Our Ref: BE/180/16/PL

**Town & Country Planning Act 1990 (as amended)
Town and Country Planning (Development Management Procedure) (England) Order 2015
Application for Planning Permission**

Development 1 No. dwelling. This application affects the setting of a Listed Building.

Location Land adj to 2 North Bersted Street Bognor Regis

LOCATION PLAN
SCALE 1:1250

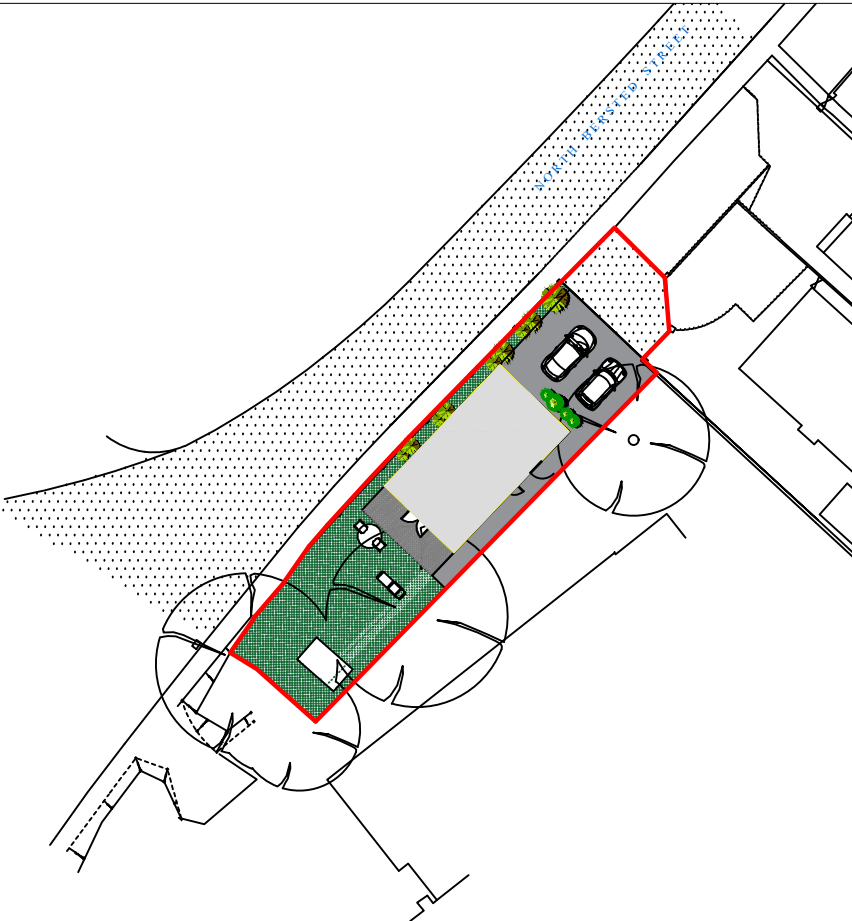
Location Plan Amend

Please submit 1 electronic or 3 paper copies of a location plan at a scale of 1:1250 or 1:2500 for rural areas. Further details of what must be included on the plan can be found in the National Validation Requirements. Please provide one named road.

BLOCK PLAN SCALE 1:500

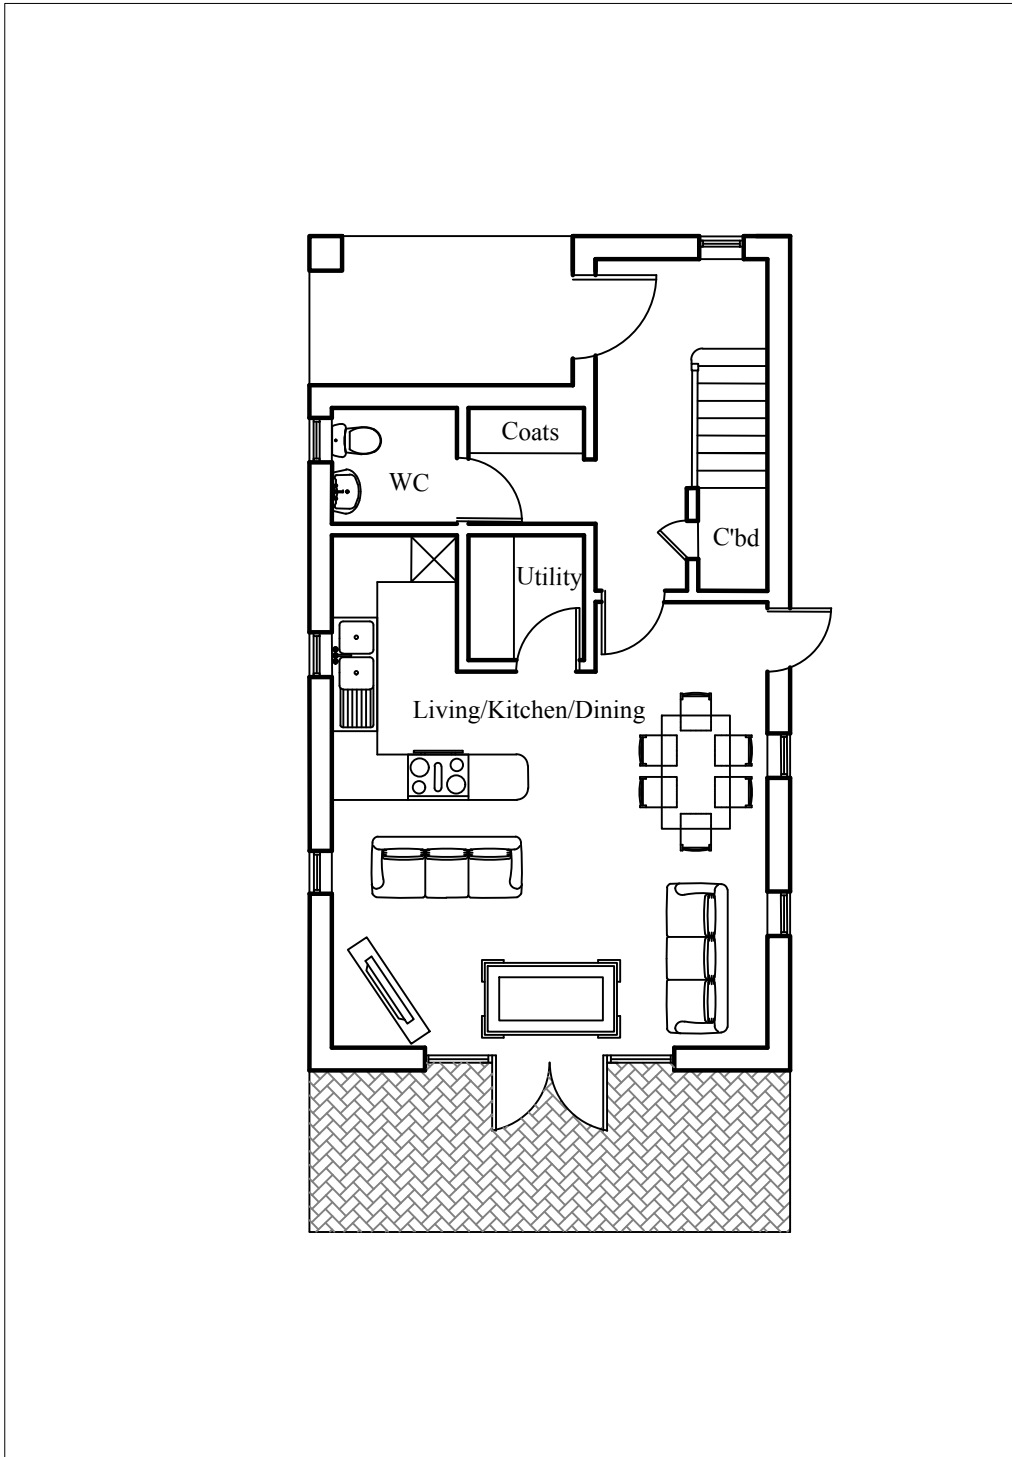
Block Plan Amend

Please submit 1 electronic or 3 paper copies of a block/site plan at a scale of 1:500 or 1:200. Further details of what must be included on the plan can be found in the National Validation Requirements. Please show the access within the red edge.

WEST ELEVATION SCALE 1:100

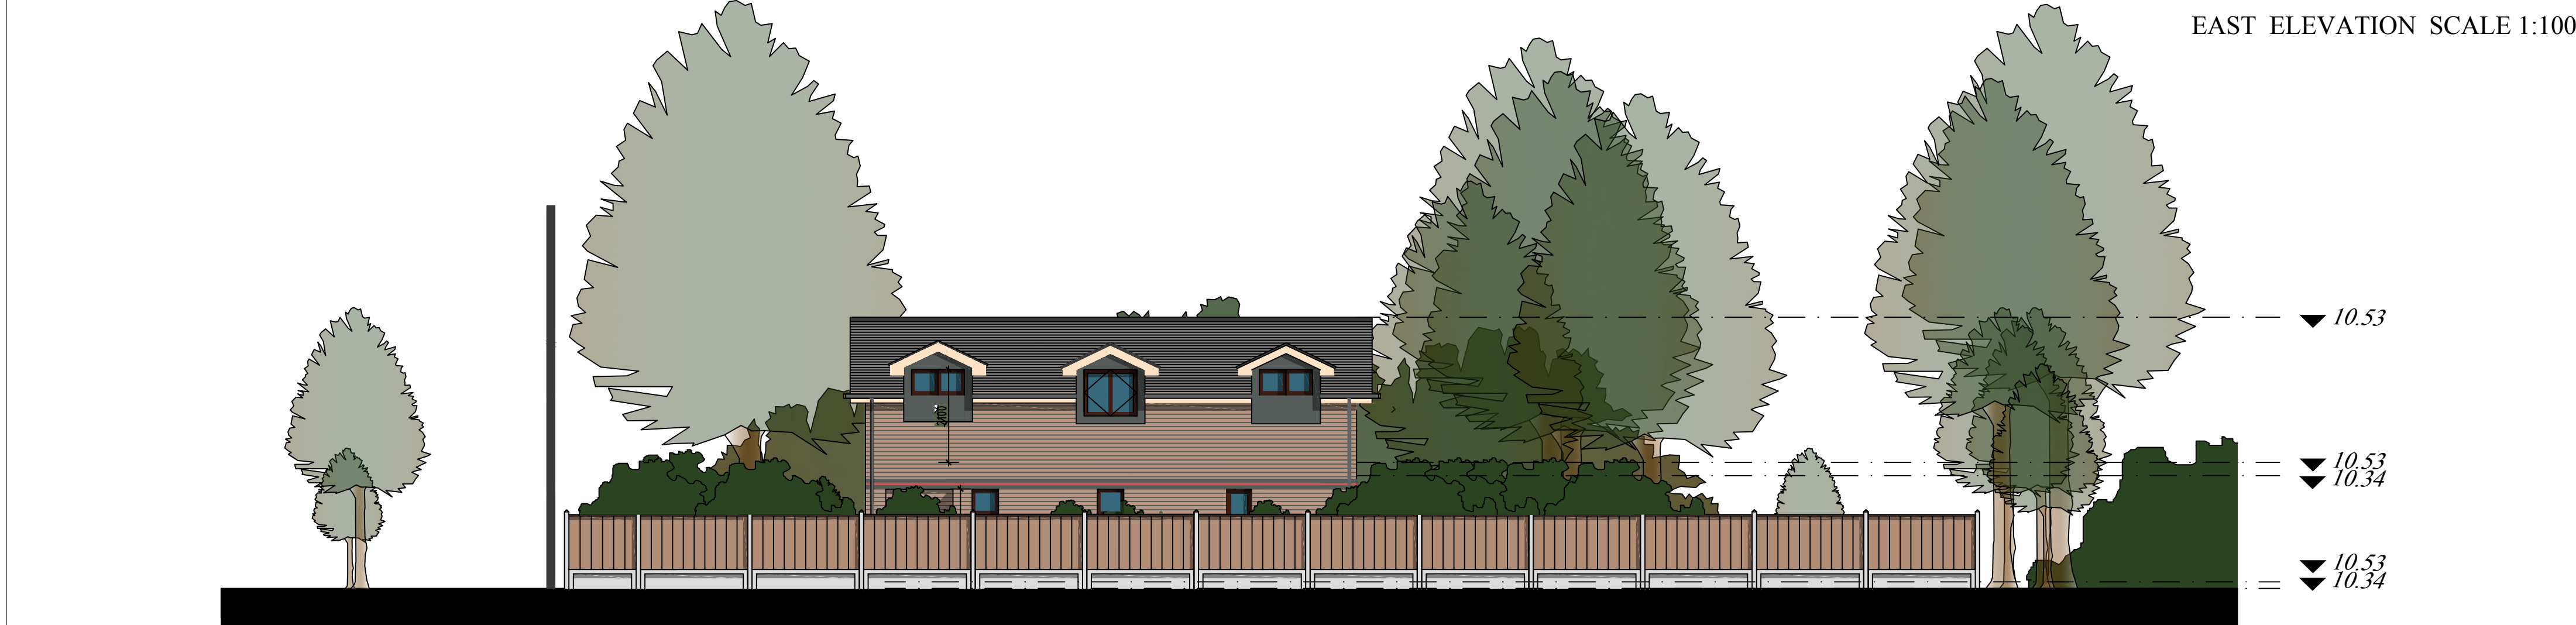
Please provide a full West elevation.
